Appeal Decision

Appeal Ref: APP/R5510/W/21/3271482

63 Victoria Avenue, Uxbridge UB10 9AH

- The appeal is made under section 78 of the Town and Country Planning Act 1990 against a refusal to grant planning permission.
 - The appeal is made by Mr S Chatur against the decision of London Borough of Hillingdon.
 - The application Ref 8499/APP/2020/2967, dated 17 September 2020, was refused by notice dated 23 November 2020.
 - The development proposed is a one bed self contained unit from existing building.
-

Proposed 1No. Bed Self Contained Unit.

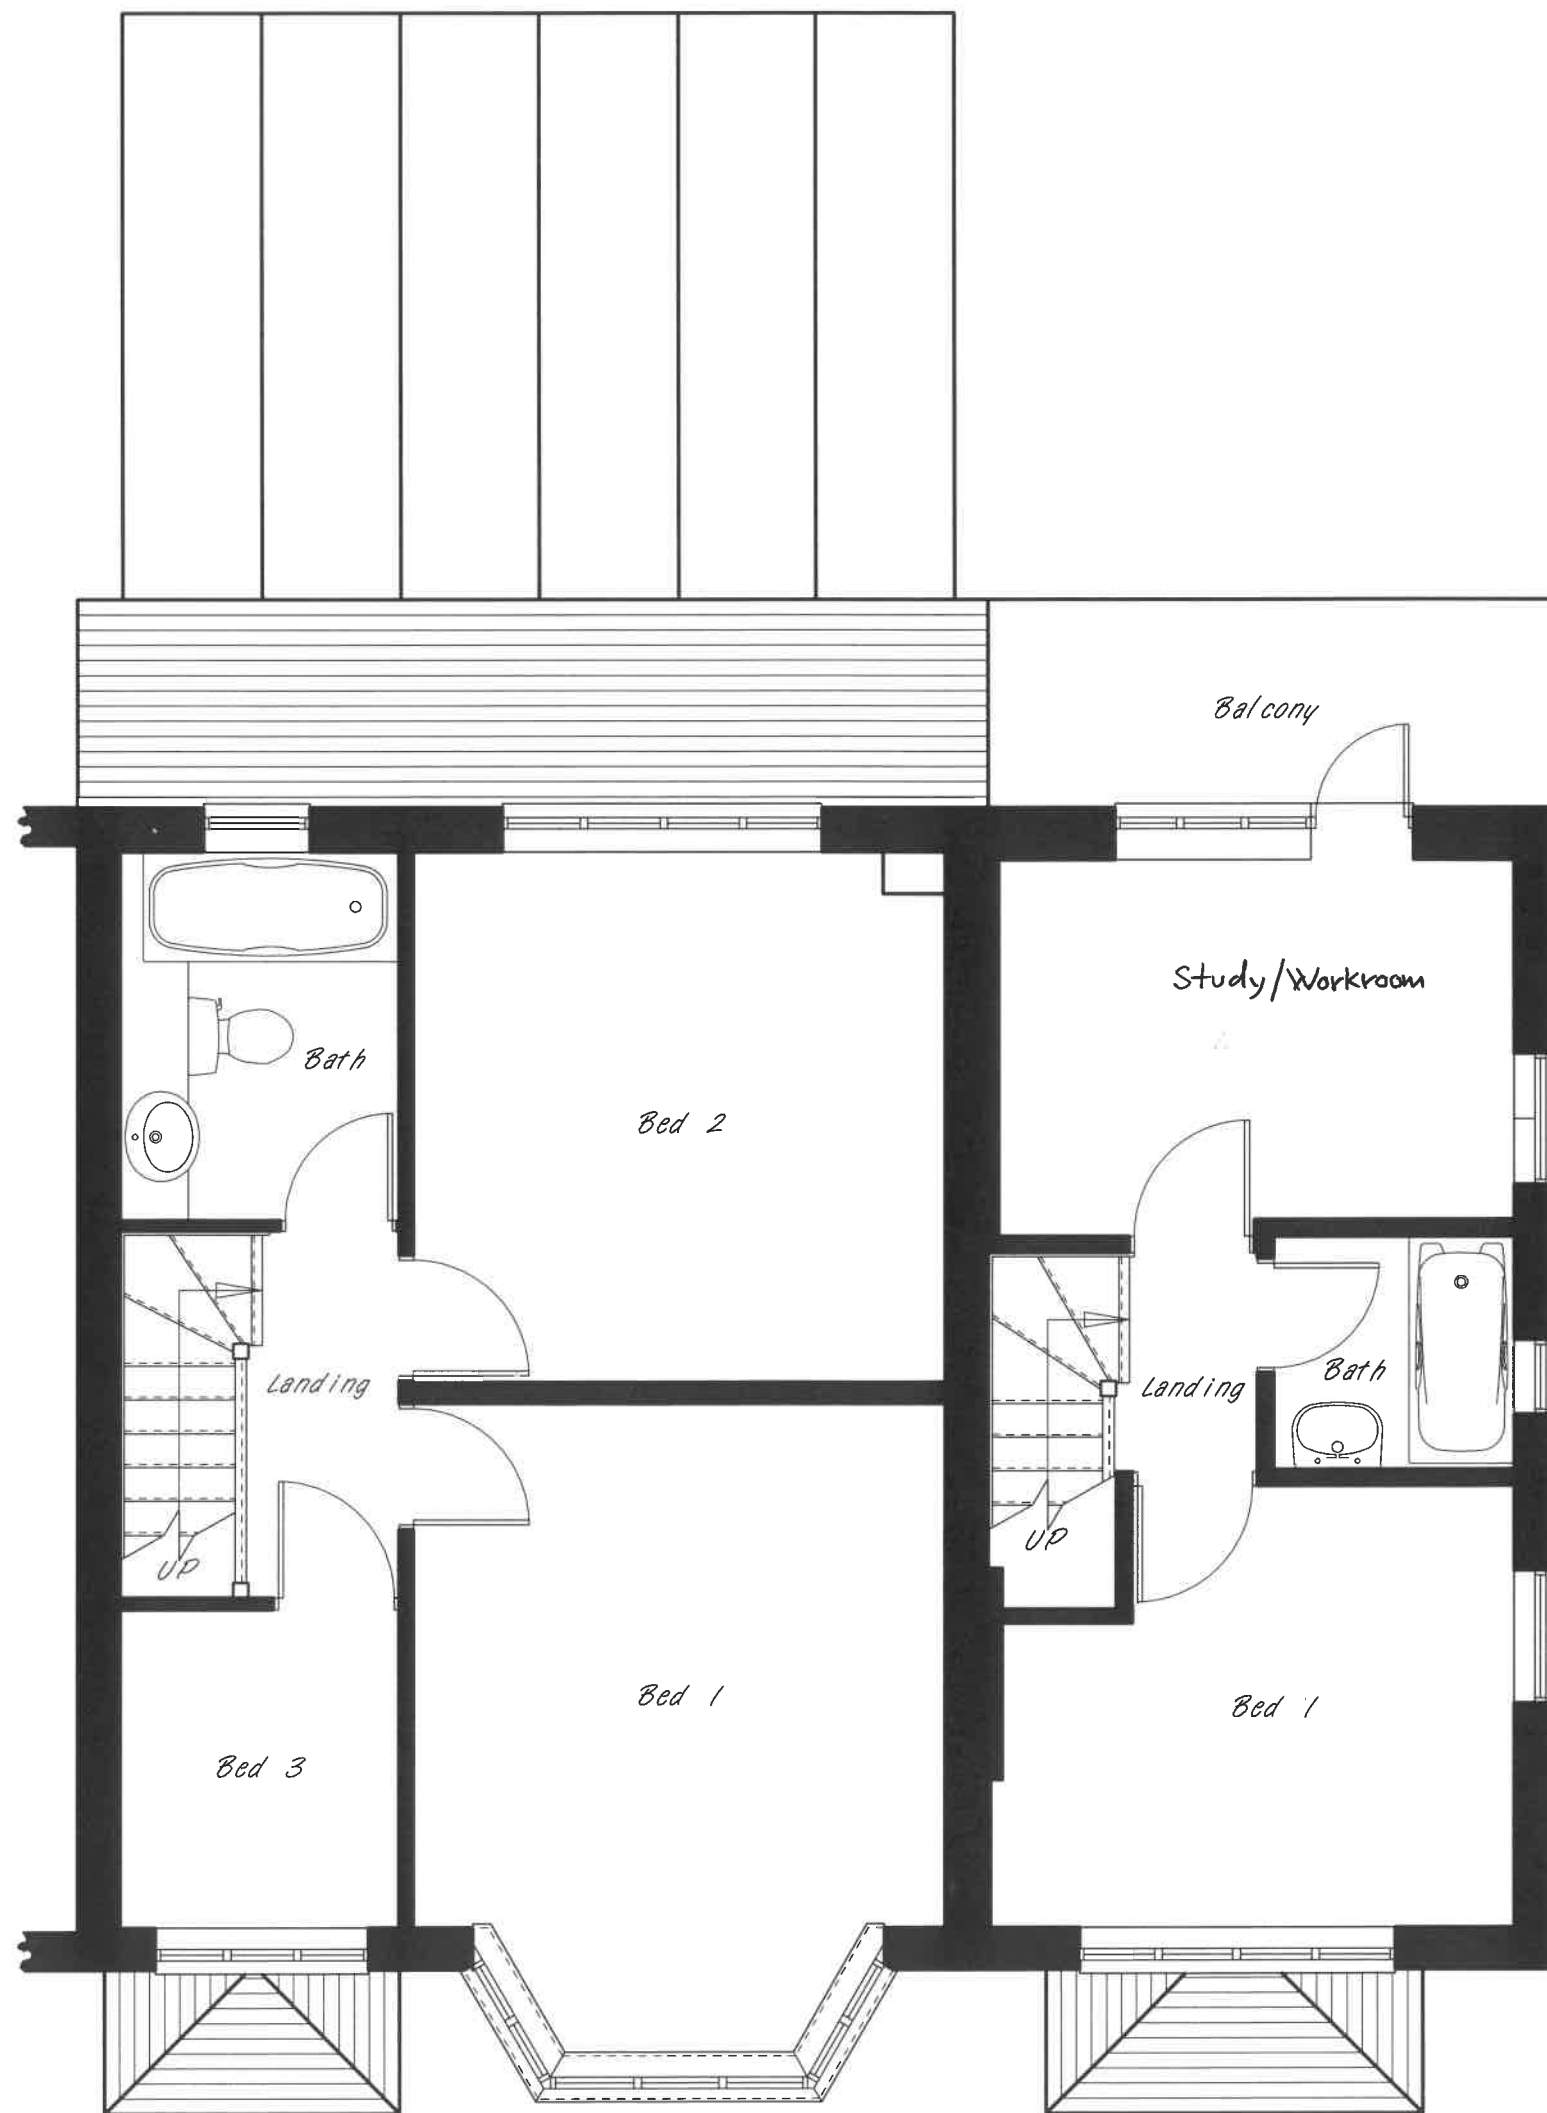
4. The appeal site is located at the intersection of Victoria Avenue and Ryefield Avenue, and accommodates a two-storey end of terrace dwelling. The host dwelling benefits from a two storey side extension, within which the proposal would be accommodated.
5. The Council has calculated that the proposal would have a gross internal area of 50 square metres spread over two floors, with the appellant arguing that the area to be provided would be 53.12 square metres. The nationally described space standards¹ (NDSS) provides guidance on the minimum internal space requirements for dwellings, with 58 square metres set as the minimum standard for a one-bedroom two-storey dwelling. Policy D6 of the London Plan (LP) and Policy DMHB 16 of the Local Plan² requires that housing developments

6. Given that the NDSS, LP and Local Plan figures are minimum standards which are intended to act as a benchmark for high quality design, the shortfall in the proposed floorspace provision is not appropriate, and the proposal would provide unsatisfactory living conditions for future occupiers. Additionally, whilst it is noted that the description of development stated the proposal is for a one-bedroom dwelling, the upstairs layout details a study/workshop with access to a balcony. If this were used as an additional bedroom, neither bedroom would meet the space standards contained within the NDSS, LP and Local Plan with regards to a double room and the floor space would fall considerably below the 70 square metres required for a two-bedroom two-storey dwelling. Nevertheless, I have already found harm to the living conditions of future occupiers when considered under the one-bedroom standards.

8. During my site visit I noted that the rear garden of the appeal site contained a number of outbuildings and an extension that do not appear on the submitted plans. As such, whilst the plans demonstrate that the rear garden can be subdivided to provide private amenity space for the proposal, I am unable to assess whether the space provided would be adequate for two dwellings.
